CROSSROADS MIXED USE FILING NO. 2

CONSTRUCTION PLANS

JULY 2023

EL PASO COUNTY FILE NO. SF2238

CROSSROADS MIXED USE FILING NO.2
STREET IMPROVEMENT PLANS

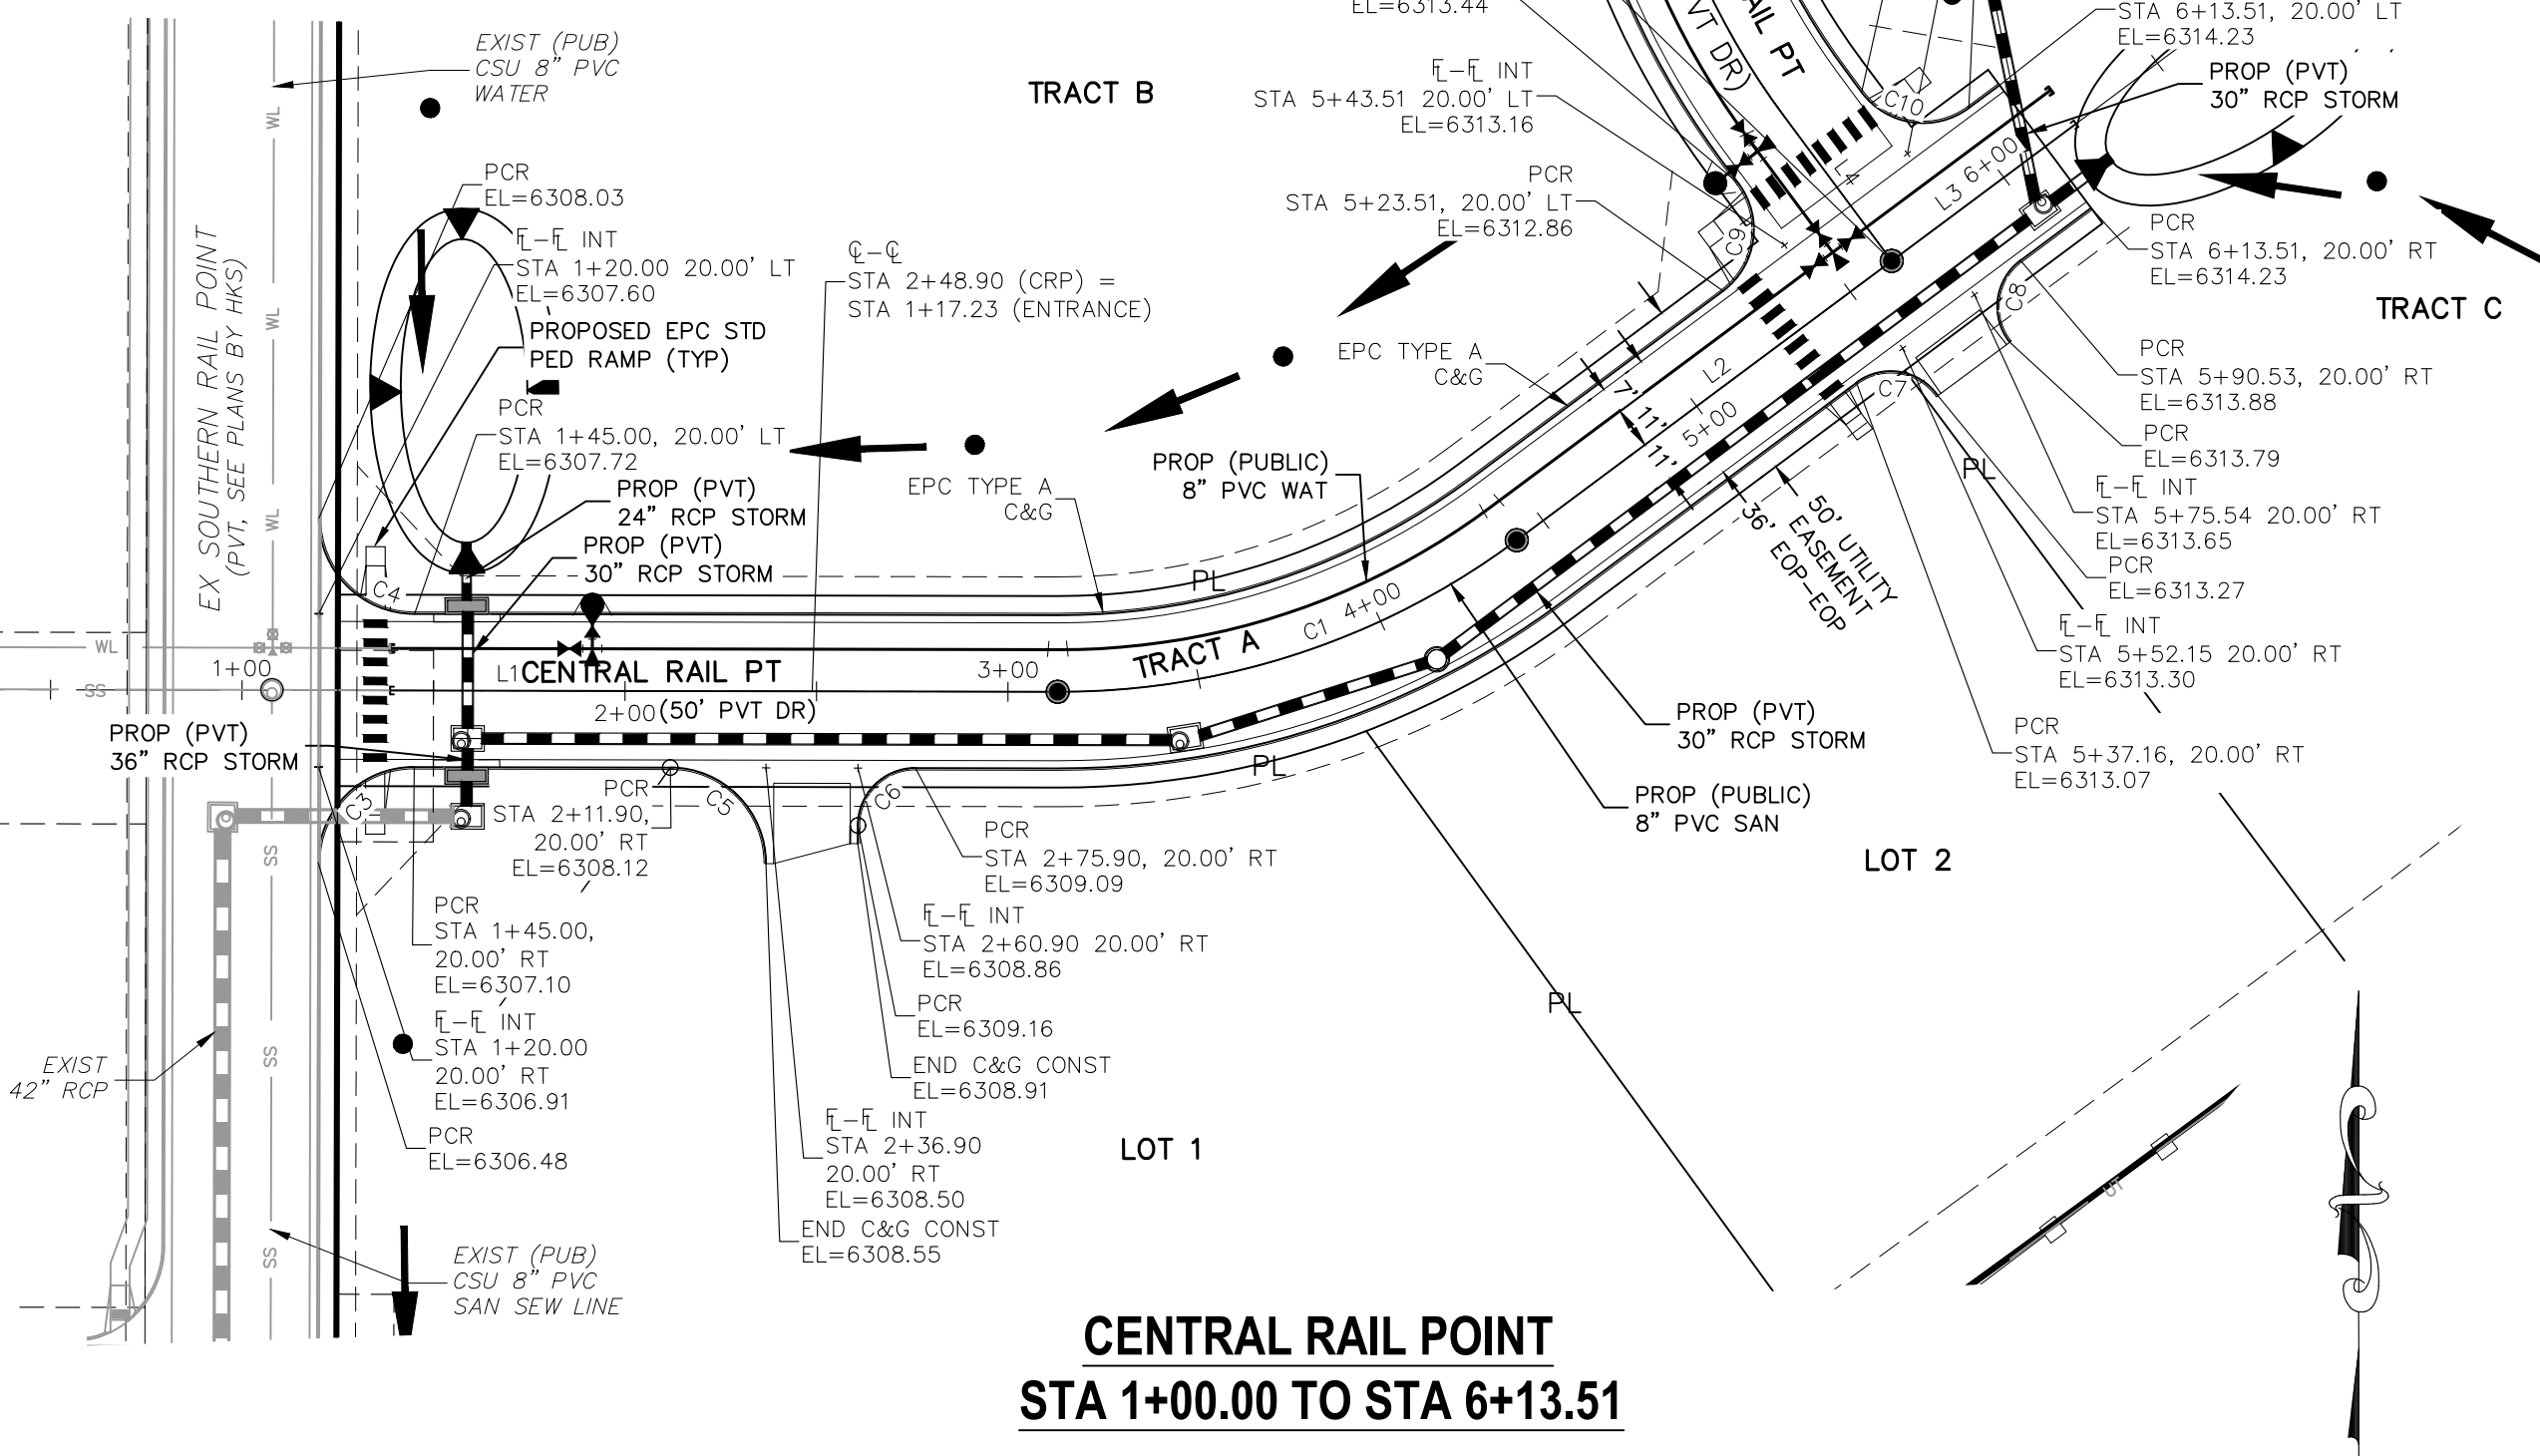
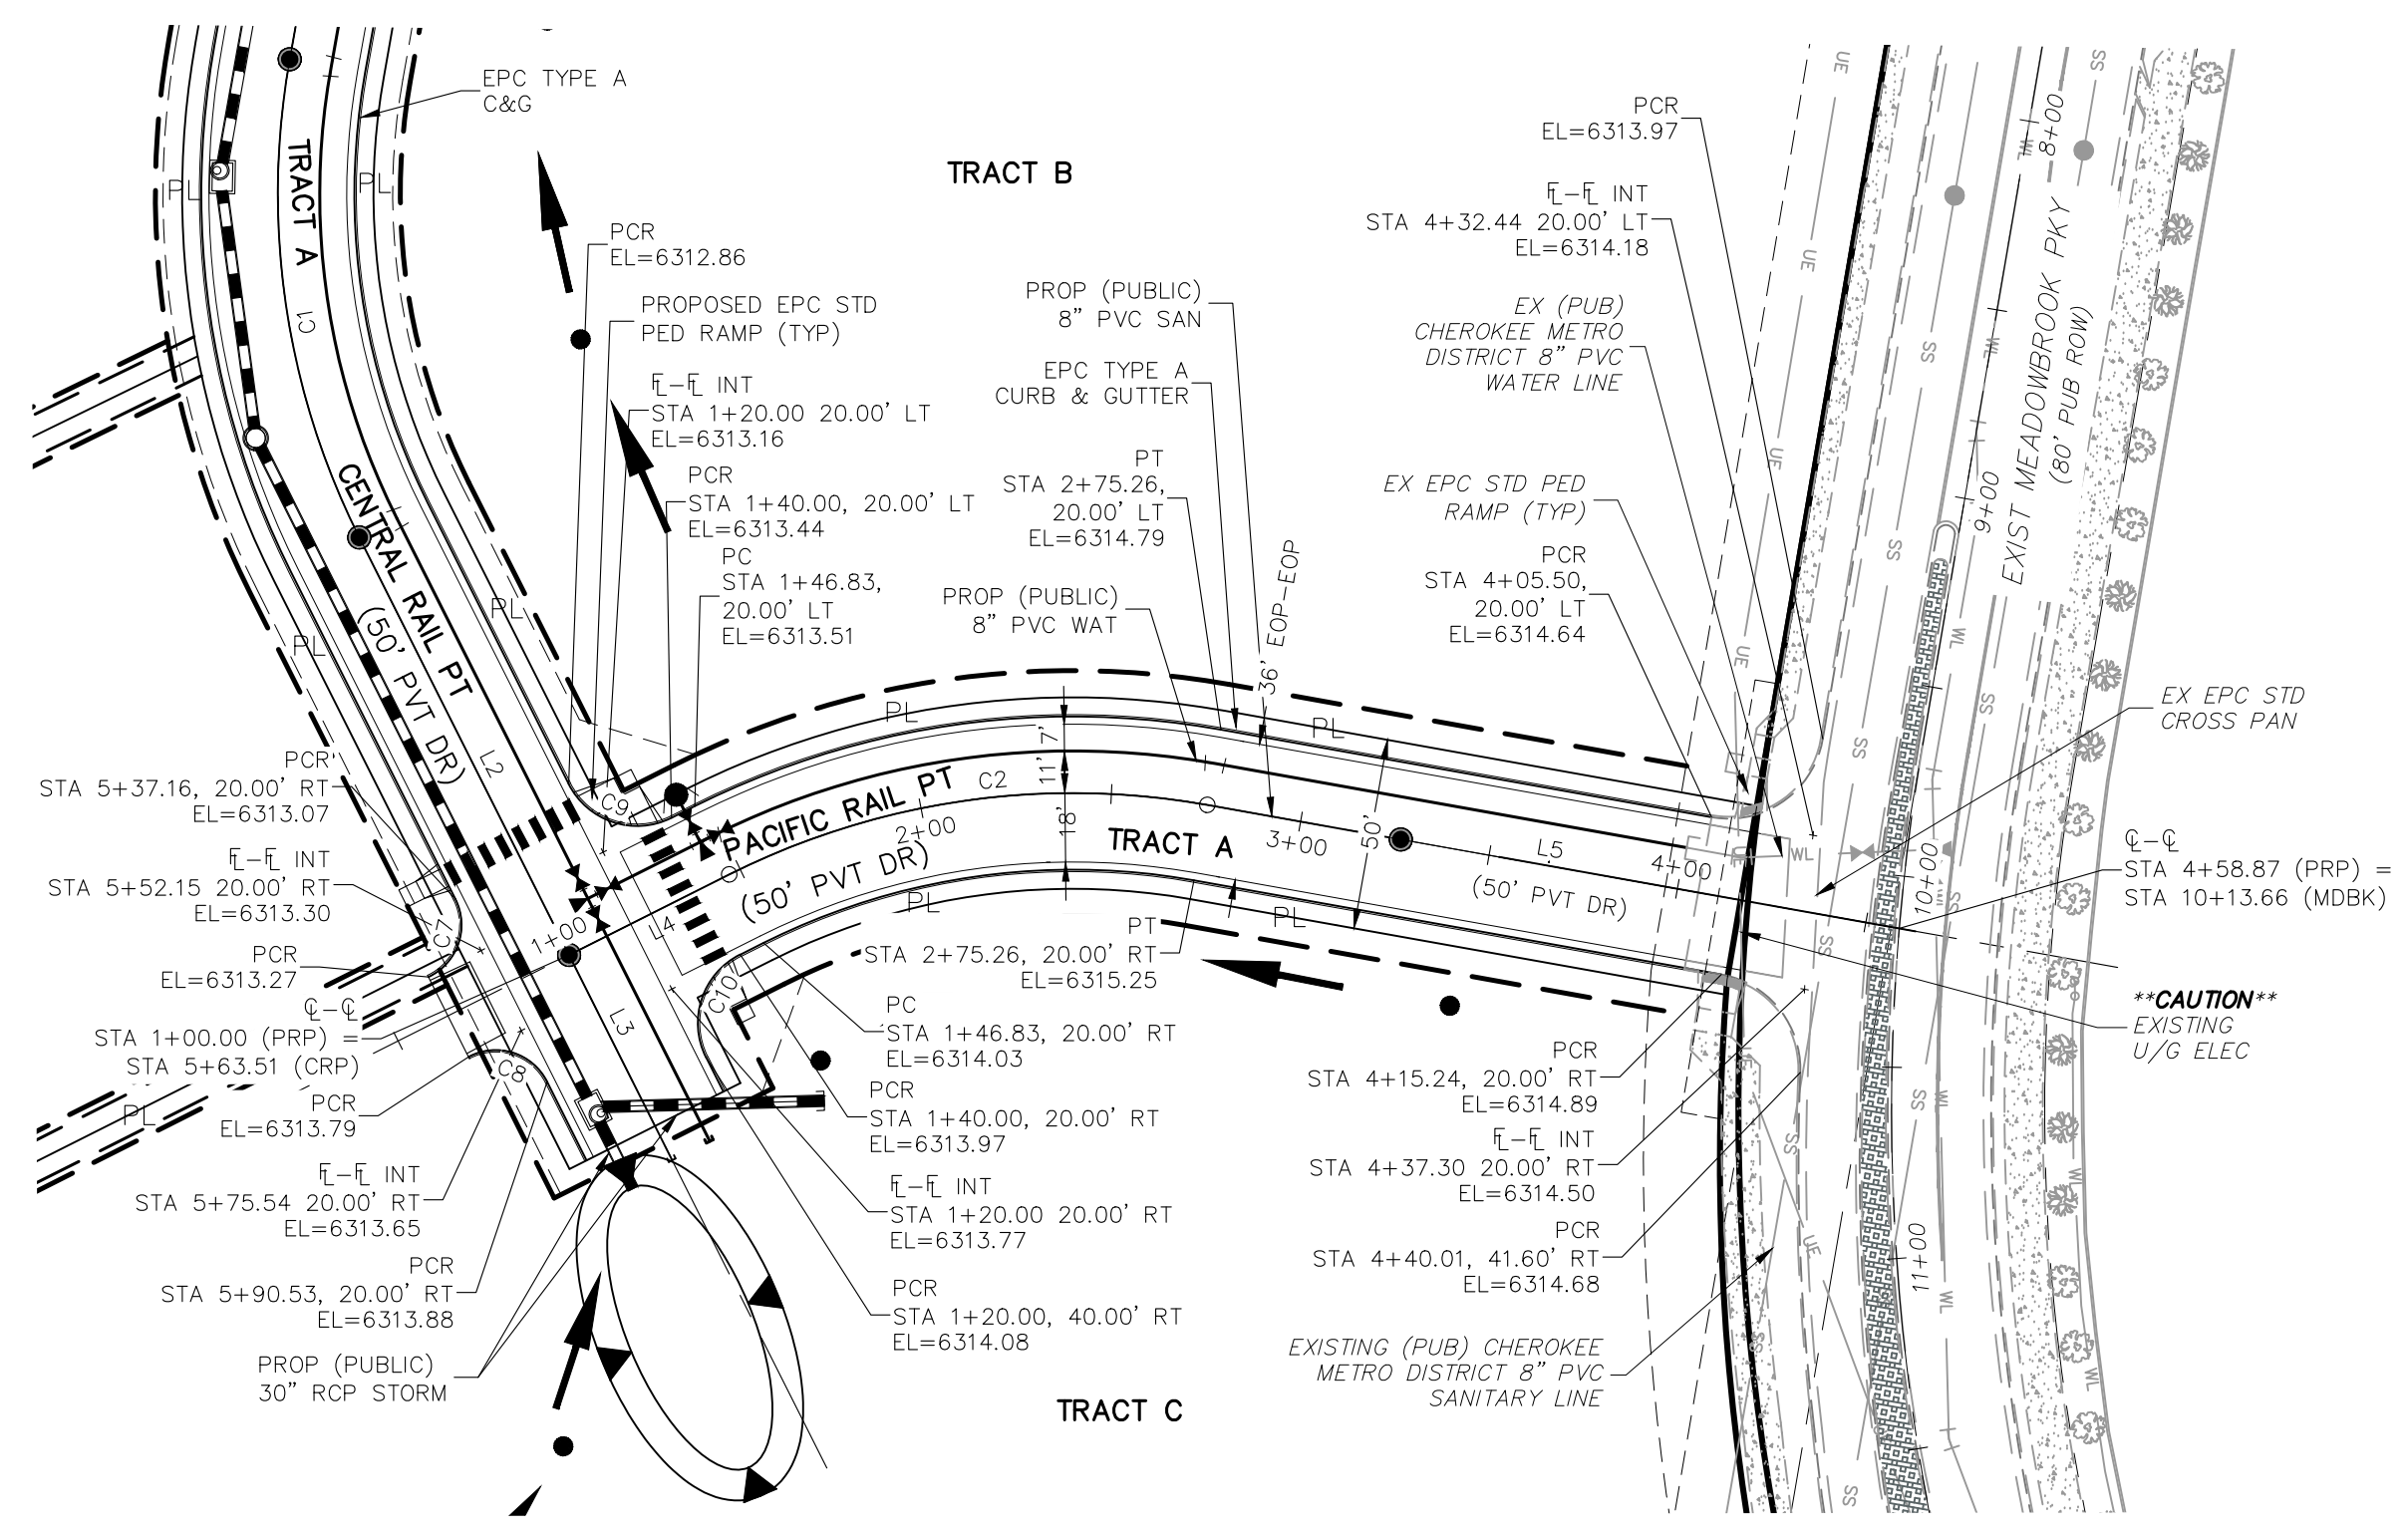
cross section shows detached. revise

It was indicated in the preliminary plan deviation and the submitted TIS that these would have a design and posted speed of 25 mph similar to a urban local classification. Please revise. Also please add note on the cross sections: per deviation request from Preliminary Plan SP2011

revise to Tract D as there is no longer a lot 2

Please extend to show the entire sidewalk along Southern Rail Pt and how it ties to the sidewalk along Meadowbrook.

Add arrows to legend

Provide receiving pedestrian ramp across the street.

Refer to EDM 2.5.2.C.3

Label

cross section show a detached sidewalk, revise to match.

Label. Provide information.

Please revise the drawings and texts so that there is no conflict. Will there be curbs cuts and a driveway for or will the sidewalk continue through?

Provide matchlines on all drawings.

Show and label running slope and cross slope on sidewalks.
